**Boston AEF (Alternative Energy Facility) / National Infrastructure Planning  
(NIP) examination**

**(Planning Inspectorate Reference: EN010095)**

**Eastern IFCA comments**

**8<sup>th</sup> June 2023**

Figure 2-6 Search area and three candidate locations for additional rock revetments roosting area situated away from The Haven shipping route

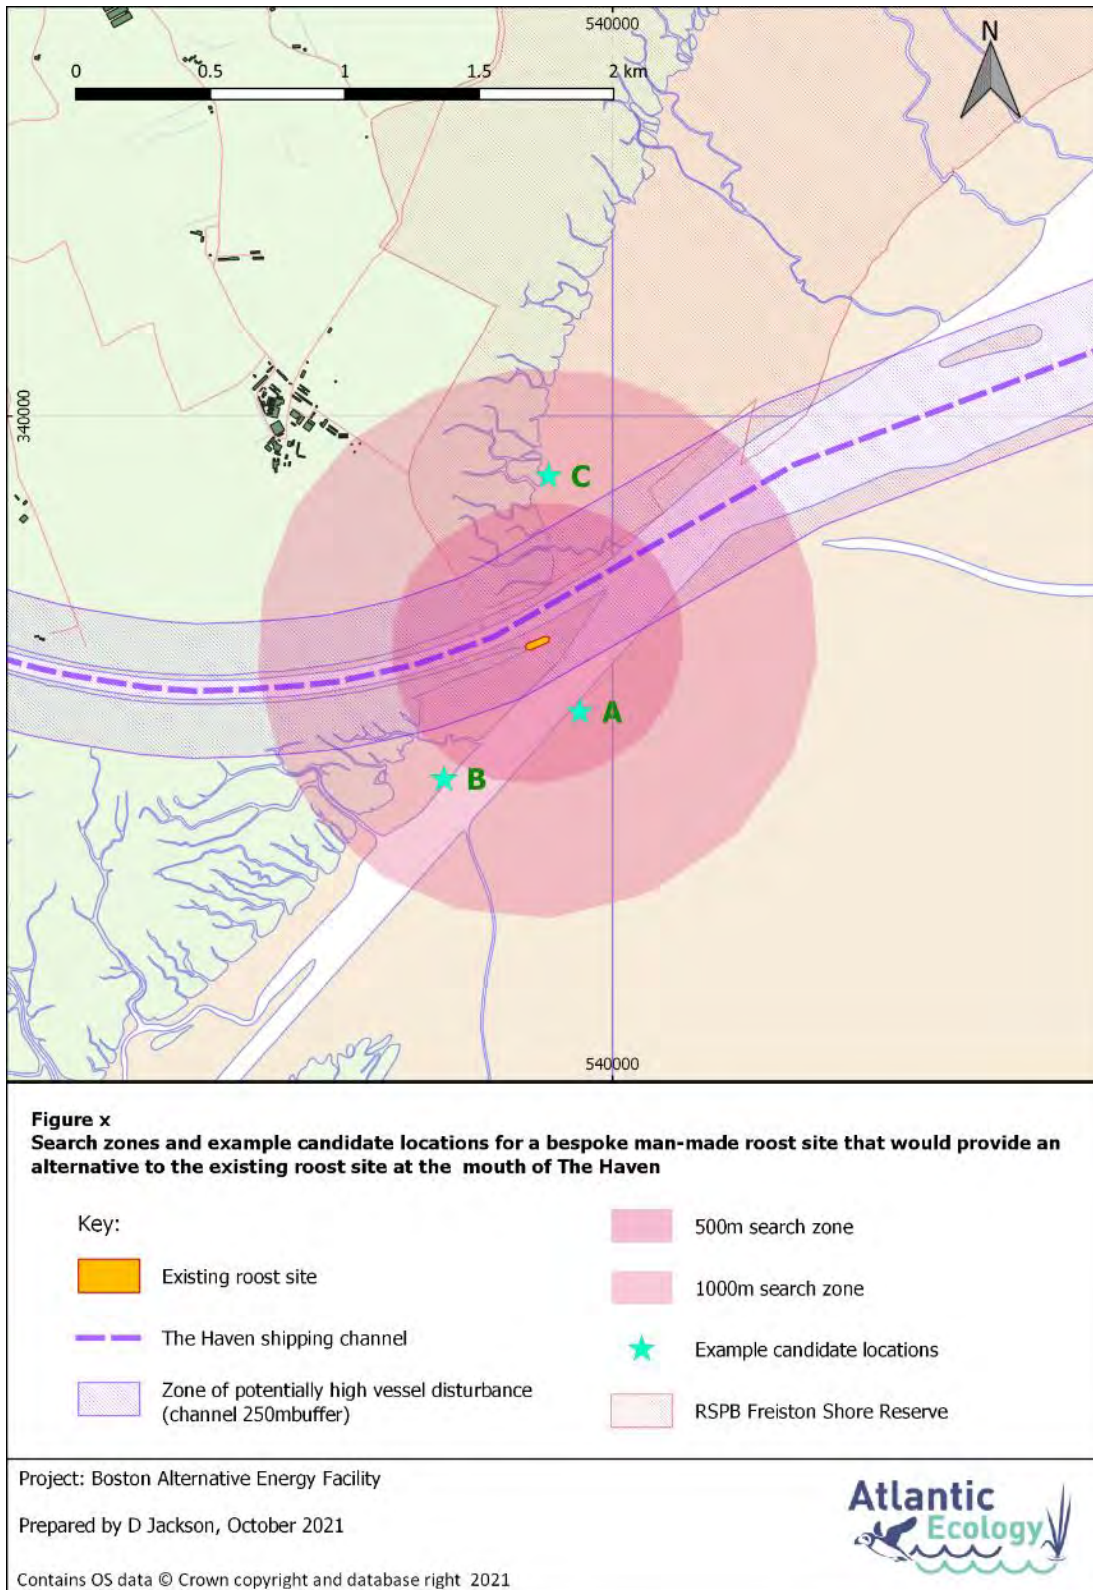
Eastern IFCA notes that the placement of rocks within the mouth of the Haven for an additional roost site is being considered, to compensate for vessel disturbance associated with BAEF. We note that this would need a Marine Licence from Marine Management Organisation. If this proposal does go ahead, Eastern IFCA requests to be kept informed and involved in discussions in relation to potential impacts on fisheries, habitats supporting fisheries, and conservation features. We would also highlight the importance of fishery stakeholders being directly consulted on any such proposal.
